Consultation Response from KC, Highways Development Management
2024/90421 Helme Edge Farm, 31, Crosland Edge, Meltham, Holmfirth, HD9 5RS
Erection of single storey ancillary store/office accommodation/tool shed/toilet/kitchen facilities/tasting room
Date Responded: 25/07/2024 Responding Officer: CNB Responding Ref: K3-16/2

Drawing Number 23_811_104

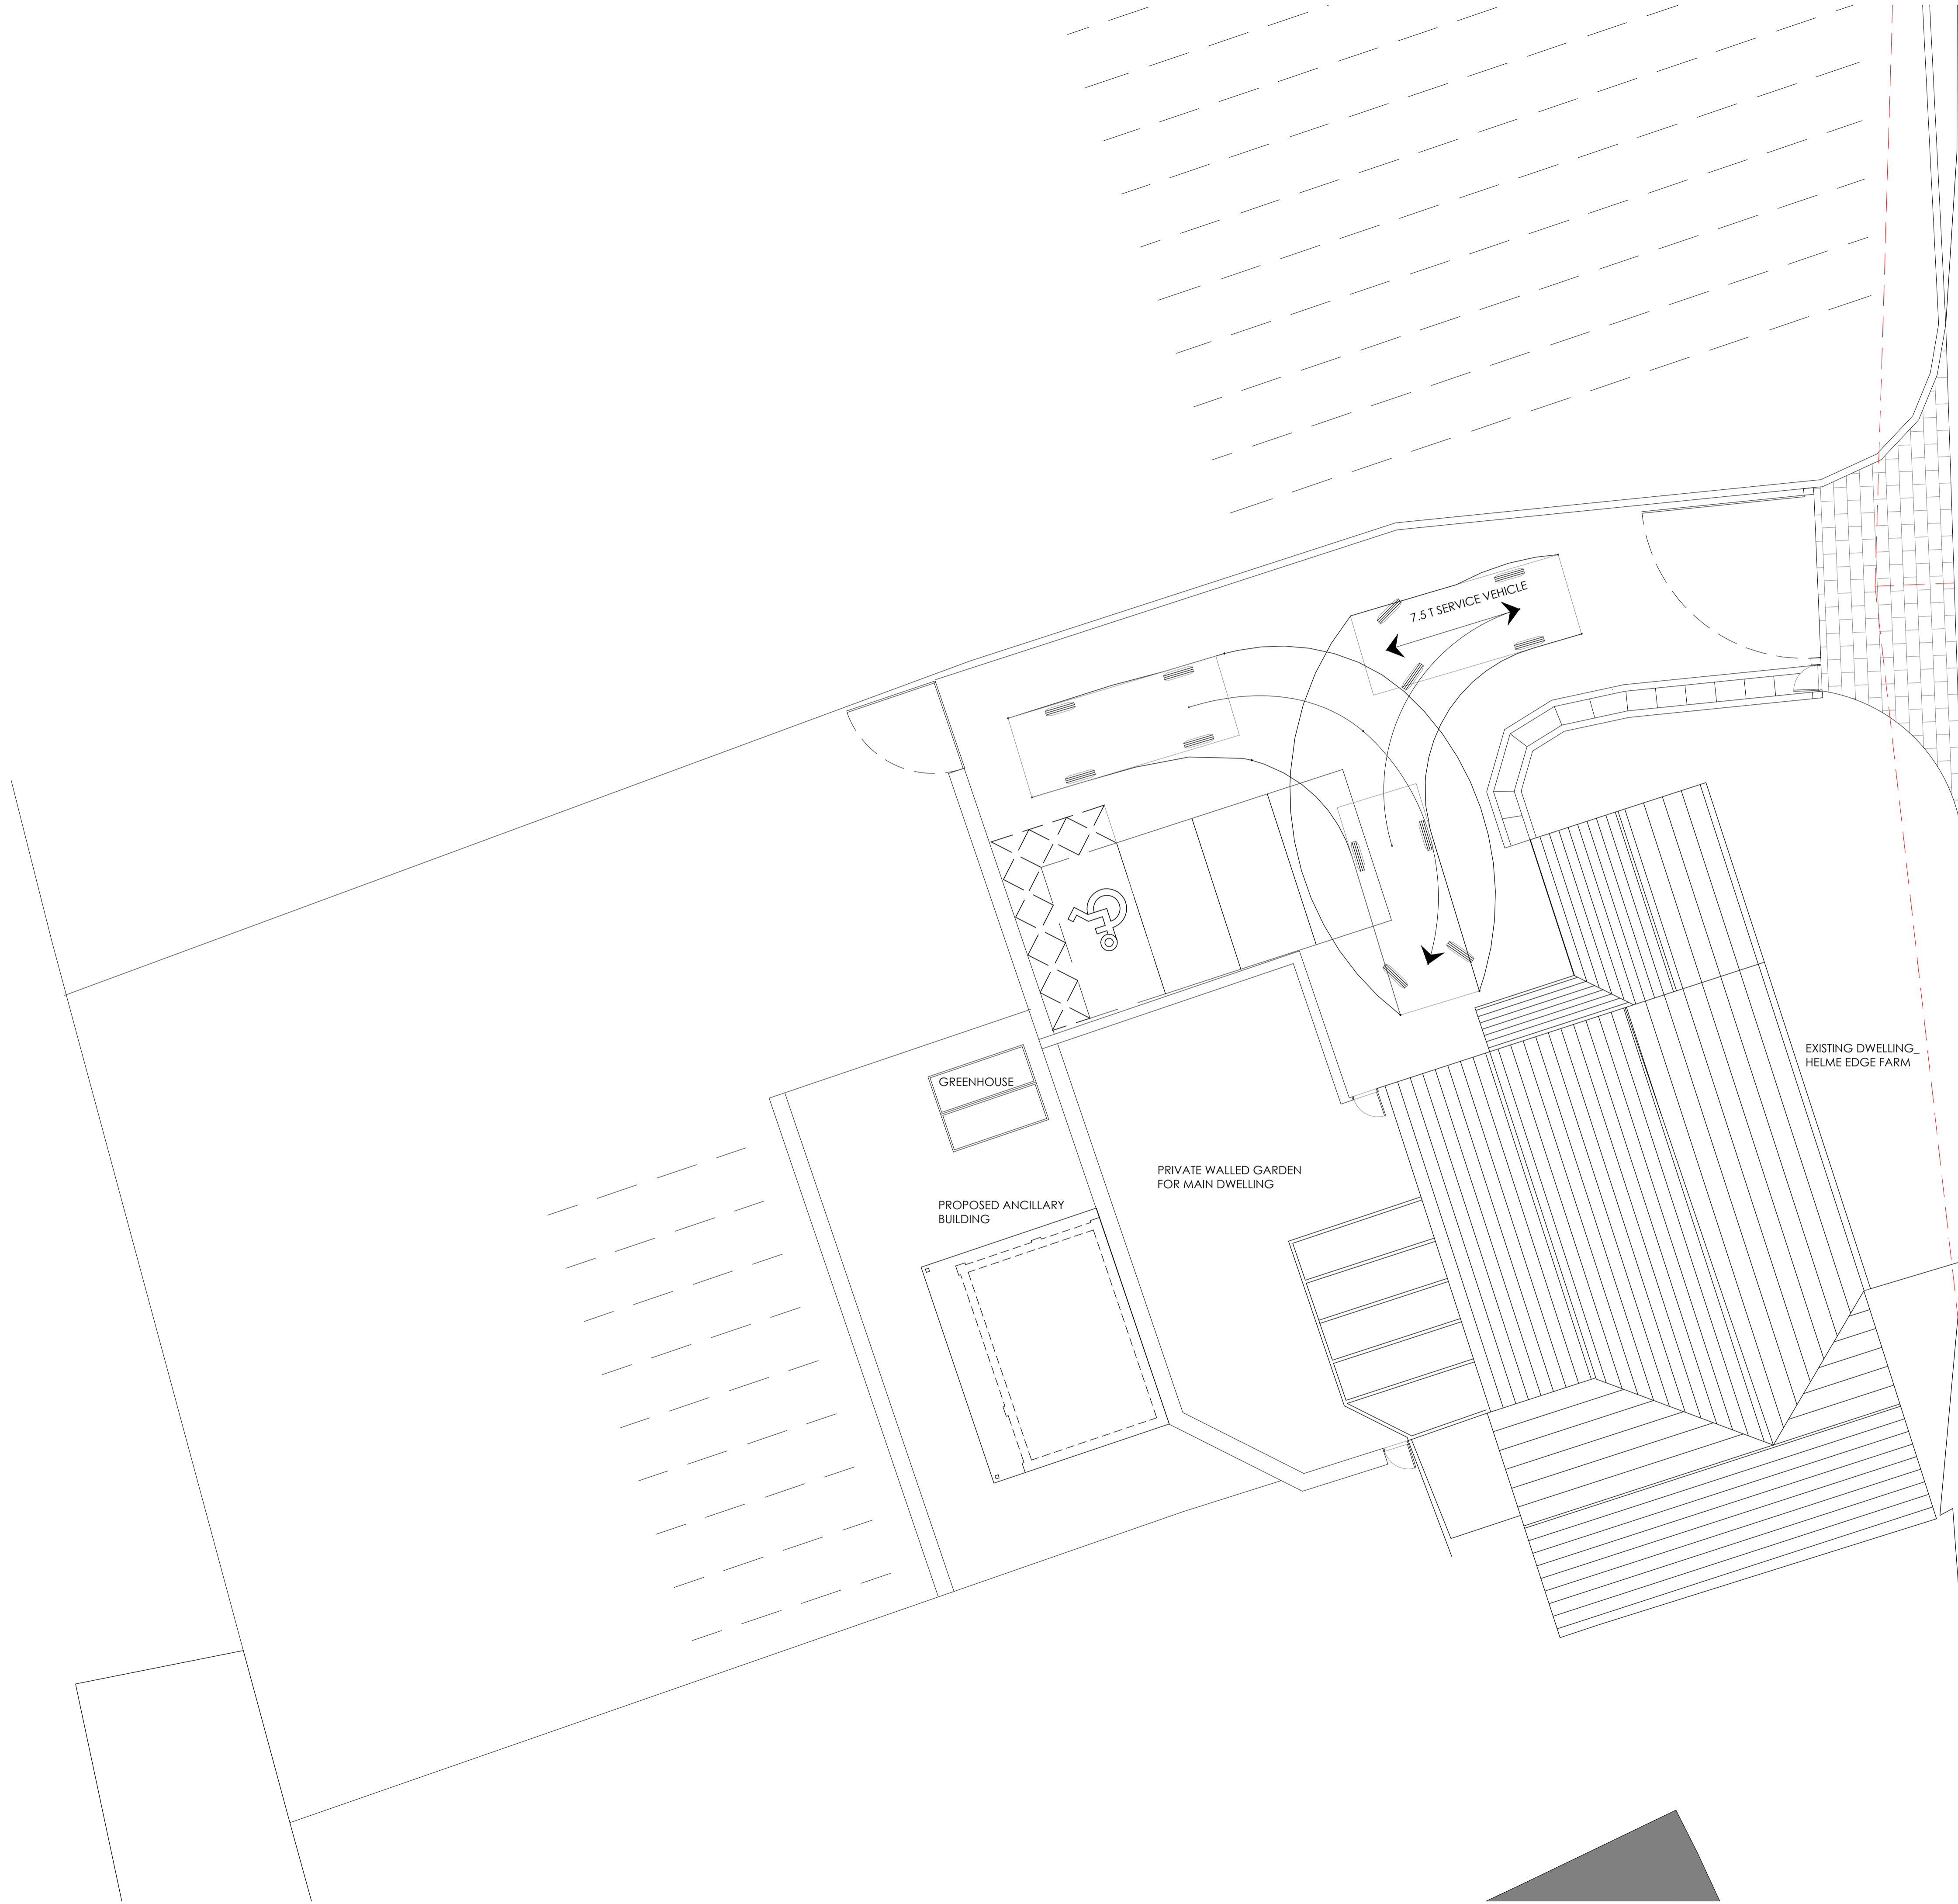
Drawing No 102 (and 104 Rev A) both show part visibility splays of 2.4m x 70m, the visibility splay of 70m to the right would be acceptable, however the visibility splay to the left is almost wholly within the national speed limit zone and so a visibility splay y-distance of 215m would be required. It is noted that on both drawings the full extent of the visibility splay is not shown on the drawing. The drawings both indicate that the boundary wall for the site will be lowered to no higher than 600mm and this is acceptable providing the full splay length is achievable.
